DECISION DELEGATED TO DEVELOPMENT MANAGER**DECISION DELEGATED TO DEVELOPMENT MANAGER**

Application No: H02-0760-20 **Applicant:** Mr & Mrs S Gilby
Proposal: Proposed two storey extension and alterations including detached garage
Location: 7 Barbers Drove South Crowland Peterborough
Terminal Date: 27th November 2020

J136-PL 2A

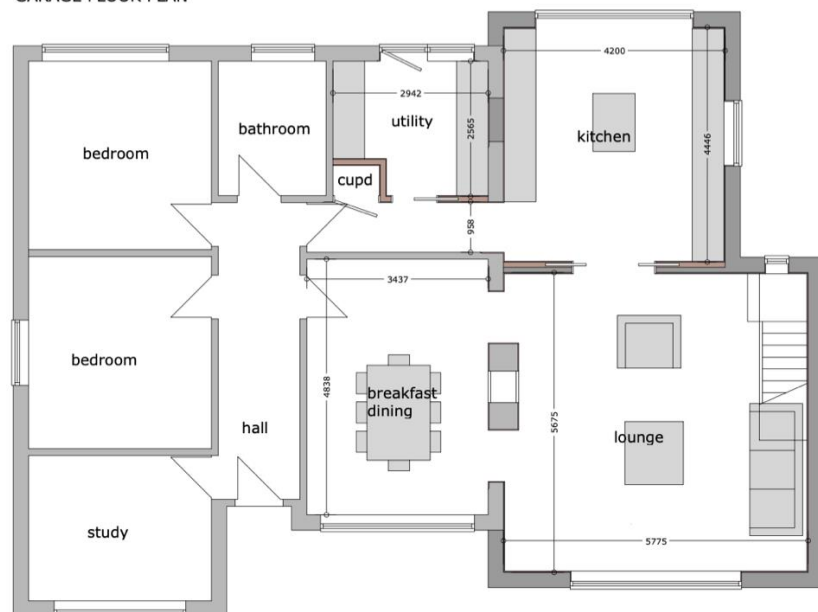
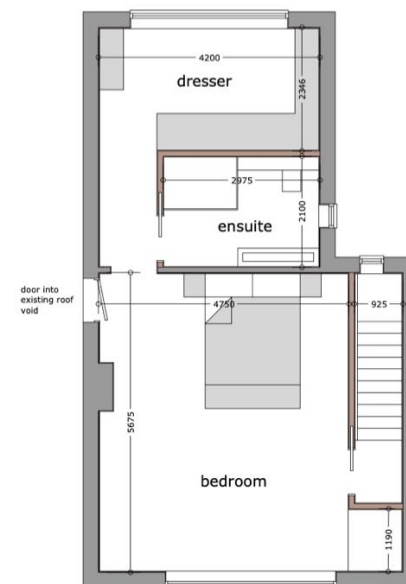
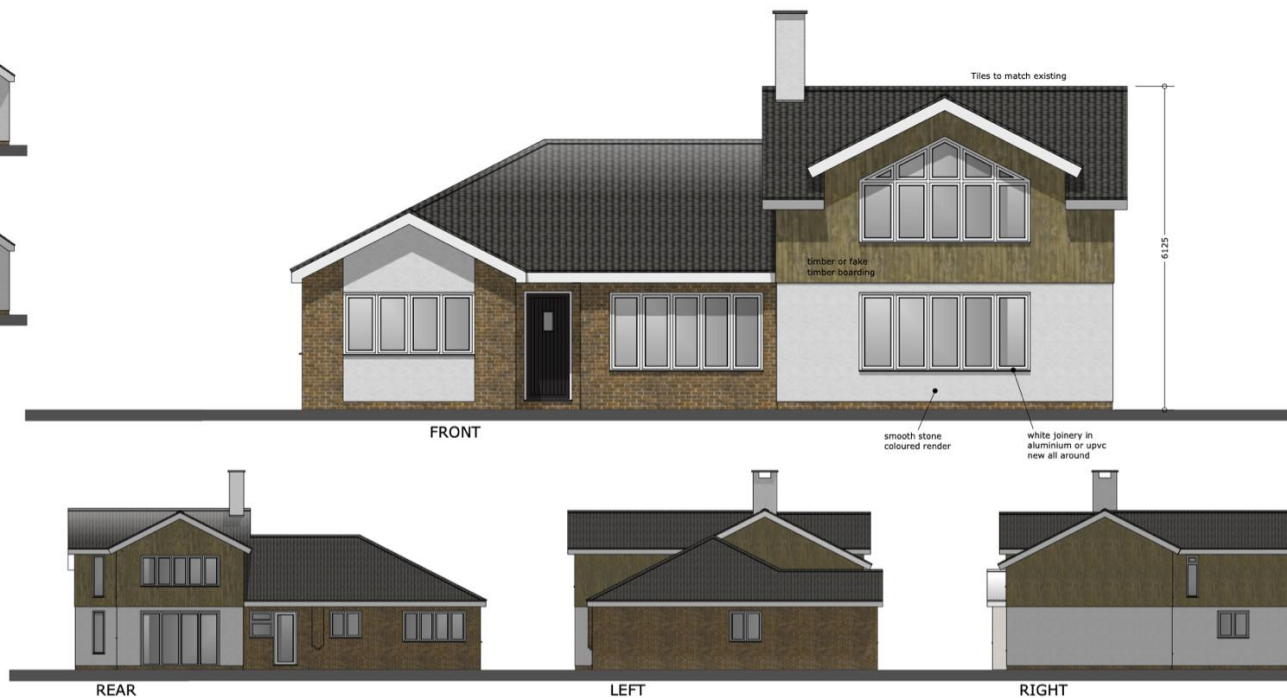
- Measurements missing from plans
- Queries whether wall is to remain and if garage is being built on neighbouring property
- Residents must be given 21 days for their comments
- Permission for detached garage has not been applied for

The proposed garage to the rear of the property would have a depth of approx. 6.1m and a width of approx. 4.5m. The maximum height of the garage is approx. 5m.

The proposed garage will be approximately 500mm from the north-western boundary and approx. 600mm to the south-western boundary. It is not considered that this separation distance will undermine the residential amenity of the occupants of No. 5 given that the distance from the rear elevation of that dwelling to the garage is approx. 26m. Furthermore, the garage would be adjacent to a neighbouring area of land where there is an unattractive building, which appears to be of steel construction and rusted, an unsightly caravan, and other structures. It is therefore not considered that the introduction of a garage in this location would have an adverse impact on the visual amenity/outlook of the neighbouring property.

Revised plans were submitted showing the distance of the garage to the boundary as requested.
